Able Marine Energy Park

Material Change 2

Statement of Common Ground

ABLE HUMBER PORTS LIMITED

Scale:	Drawn By:	Checked By:	Approved By:
NTS@A1	D Almeida	R Crum	R Crum
Date:	07/12/2020	12/02/2021	12/02/2021
Drawing No:	AME-036-10009	Revision:	D

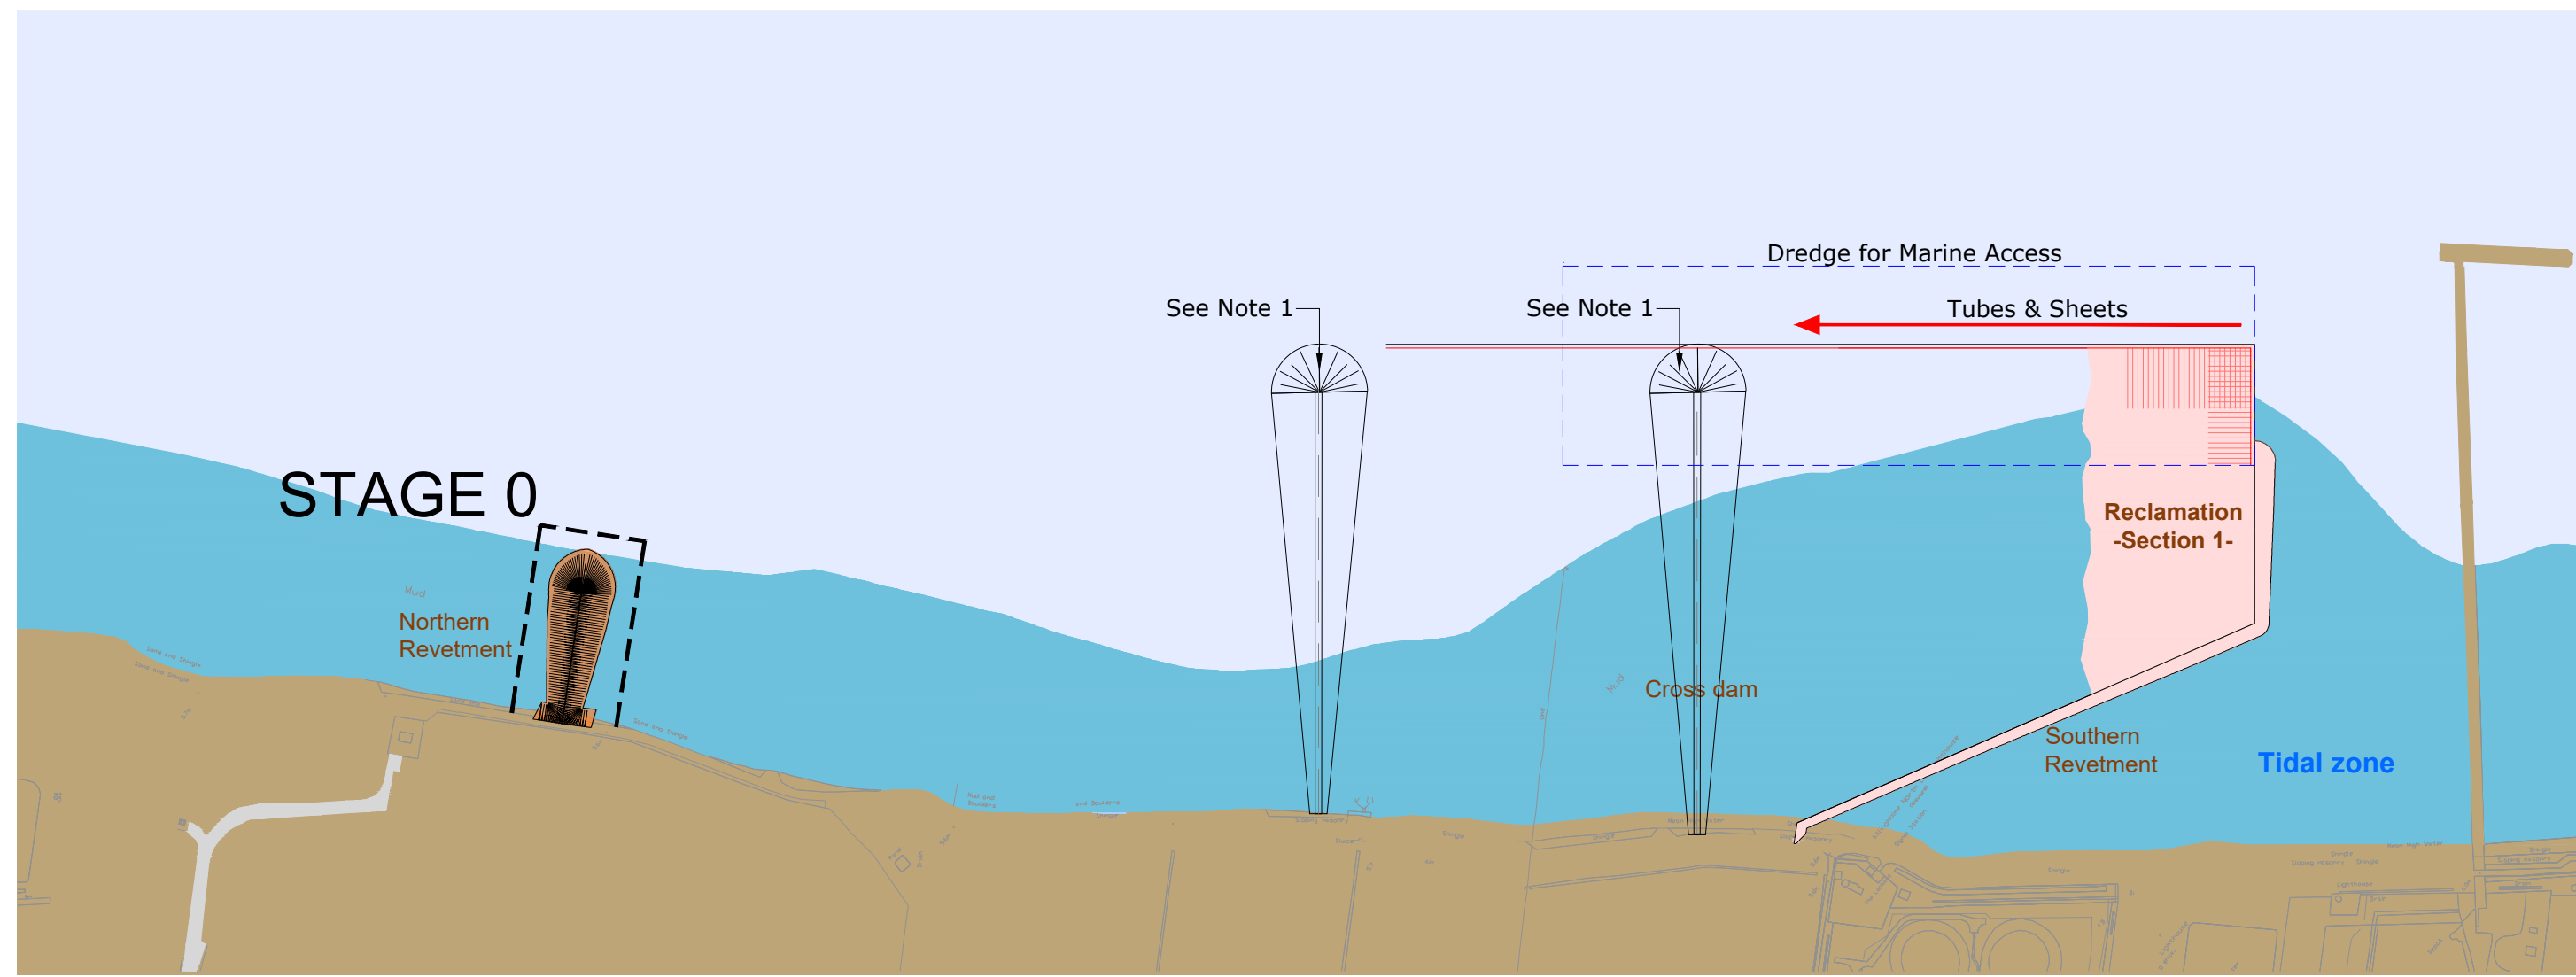
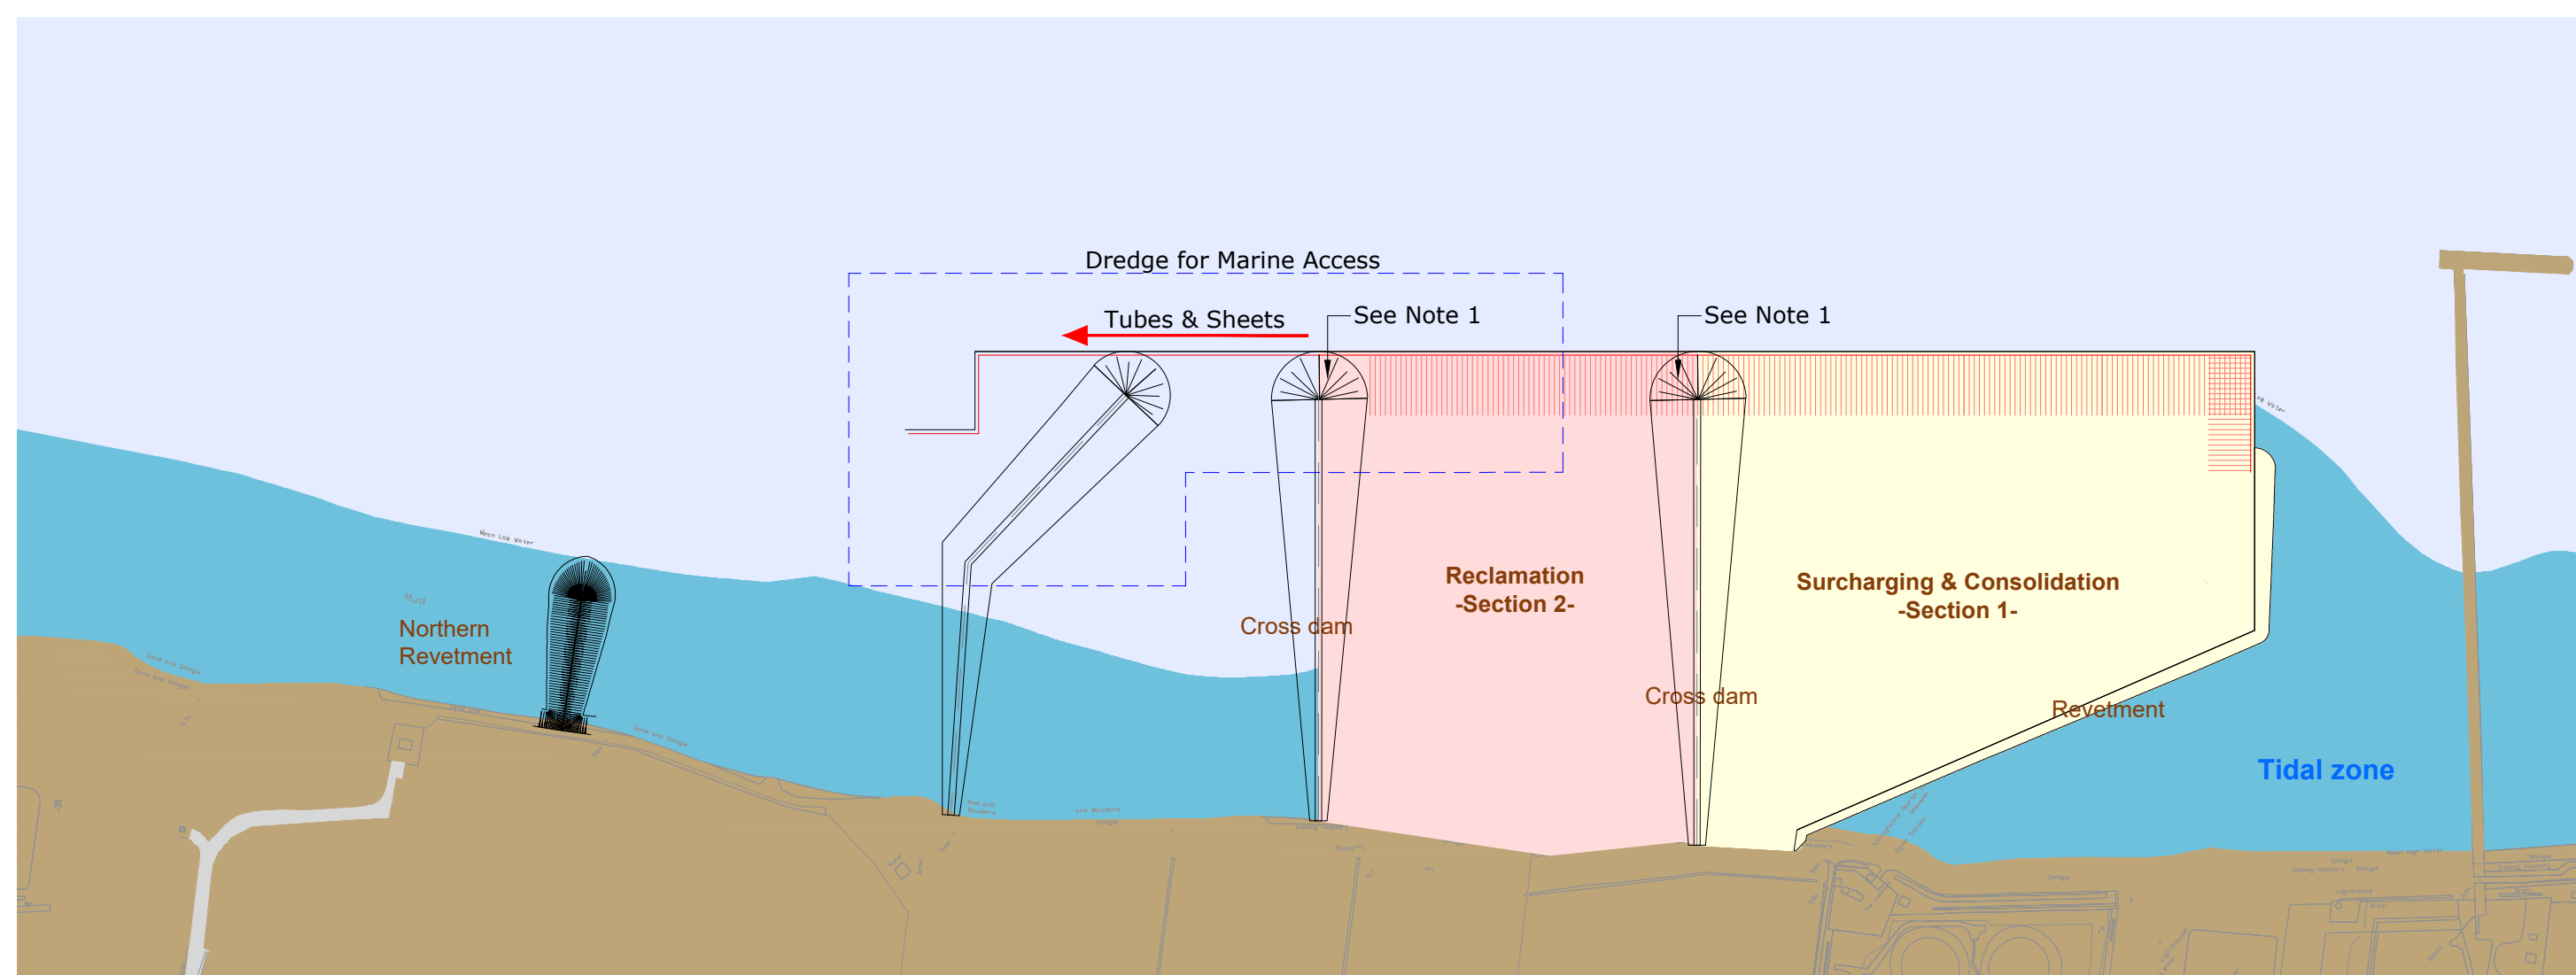
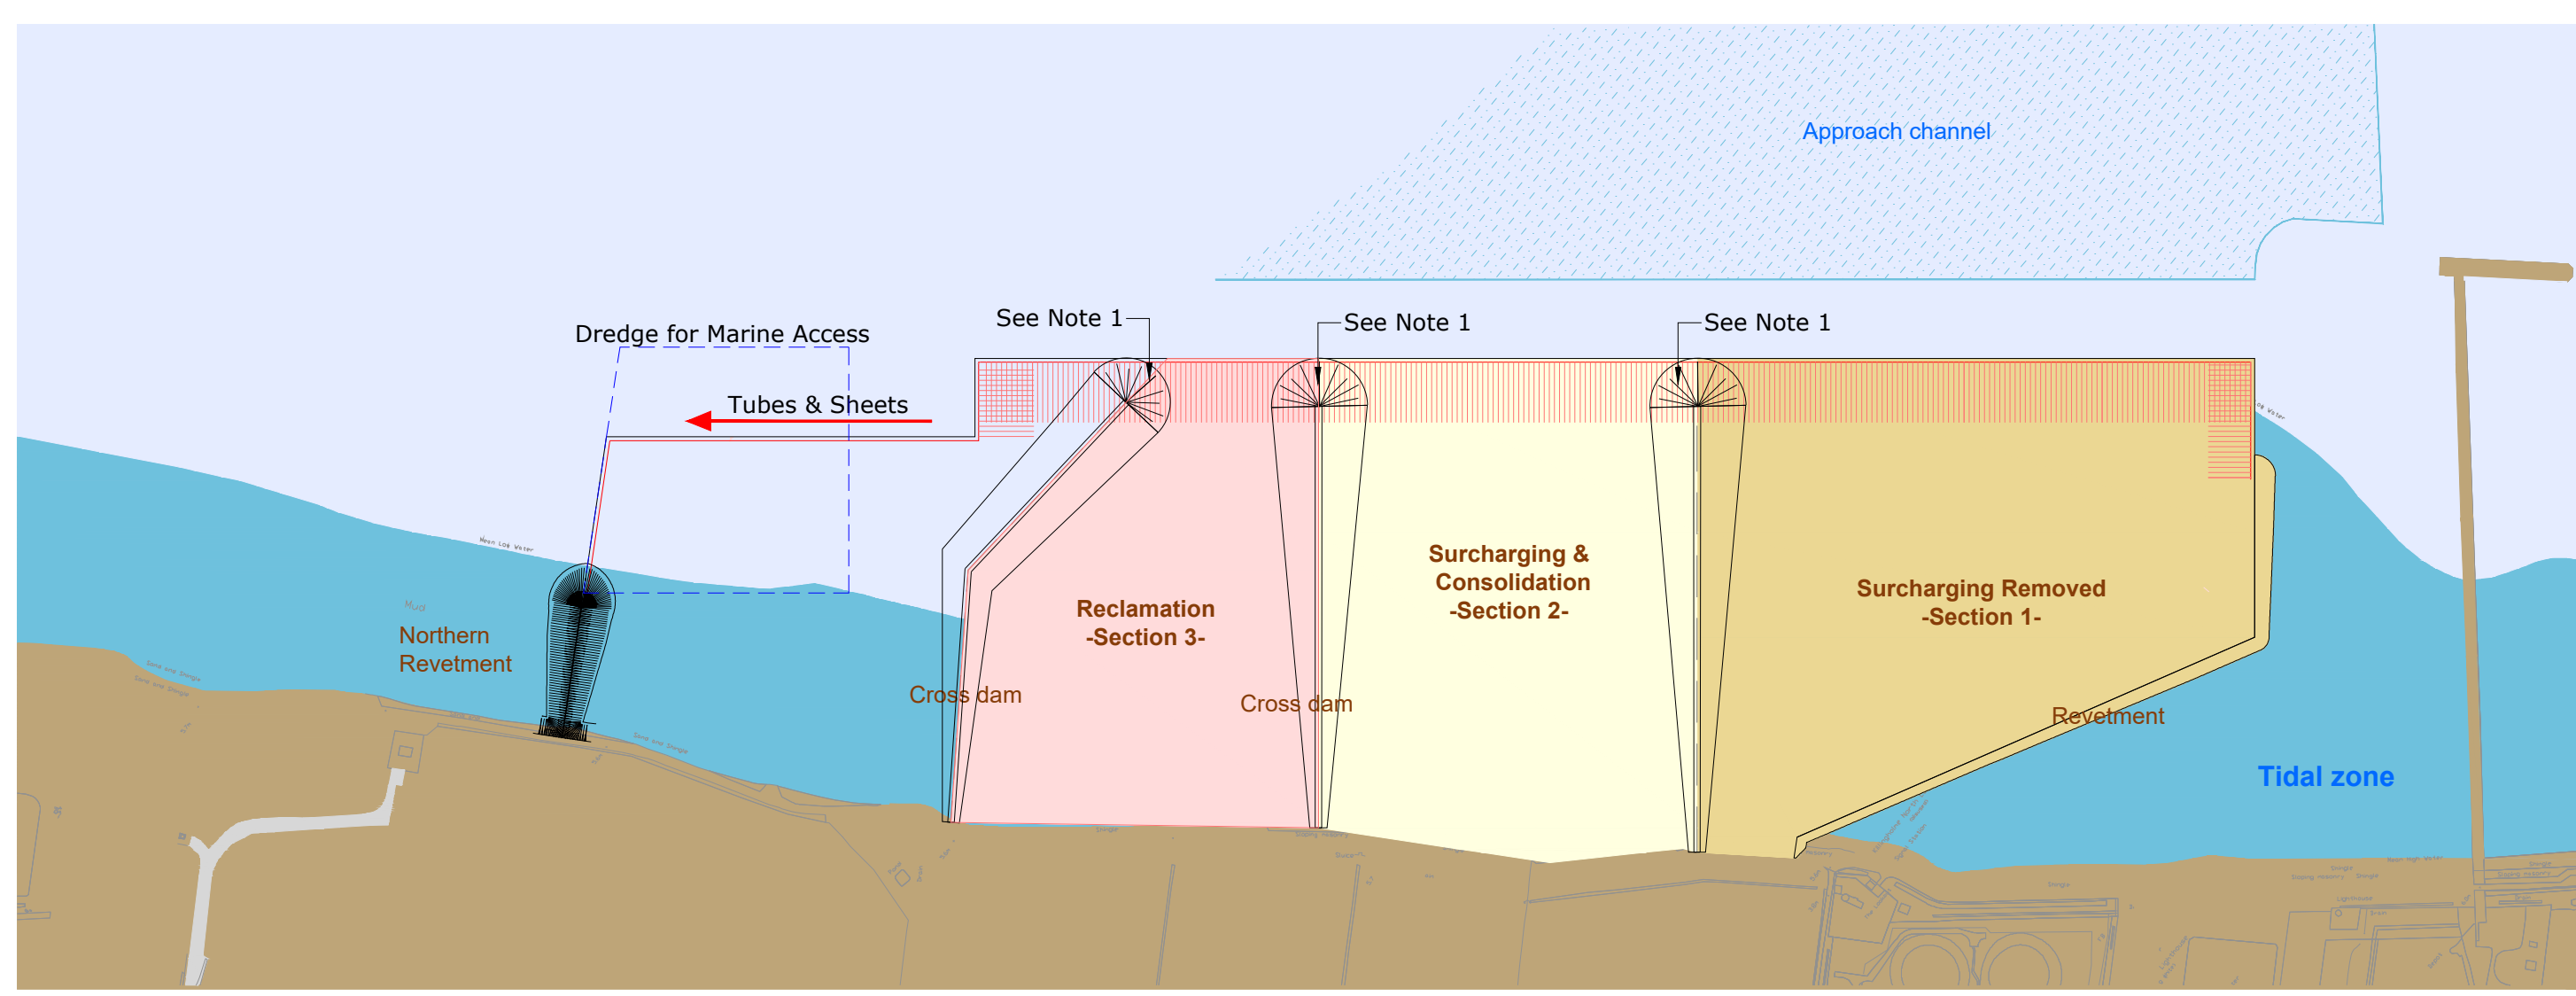
- 3.7 An additional submission has since been made by the Applicant in respect of the draft DCO Amendment Order to further amend two of the construction sequencing design drawings. The Applicant has submitted drawings AME-036-10009 (Rev D) and AME-036-10010 (Rev D) to the Planning Inspectorate, together with an amended draft Amendment Order which would permit the Applicant to follow either the construction sequencing drawings previously submitted (AME-036-10009 (Rev C) and AME-036-10010 (Rev C)) or the amended versions.

- 3.8 The original construction sequence was to build the quay from north to south; the material change proposes reversing this to build the quay from south to north. A variation on both of these has been proposed, namely building the revetment at the north first, and then building the quay from south to north, starting with a revetment at the south. This would mean that the specialist equipment needed to build the revetments would only need to be mobilised and used for one period at the start rather than being re-mobilised to build the northern revetment later.

- 3.9 The parties note that AME-036-10009 (Rev D) and AME-036-10010 (Rev D) have not yet been published on the Planning Inspectorate website. The Applicant has discussed the amended drawings with C.Ro and C.Ro has no immediate concerns regarding the proposed changes. Nevertheless, C.Ro reserves the right to make further representations once the documents have been published and it has had the opportunity to review them in detail.
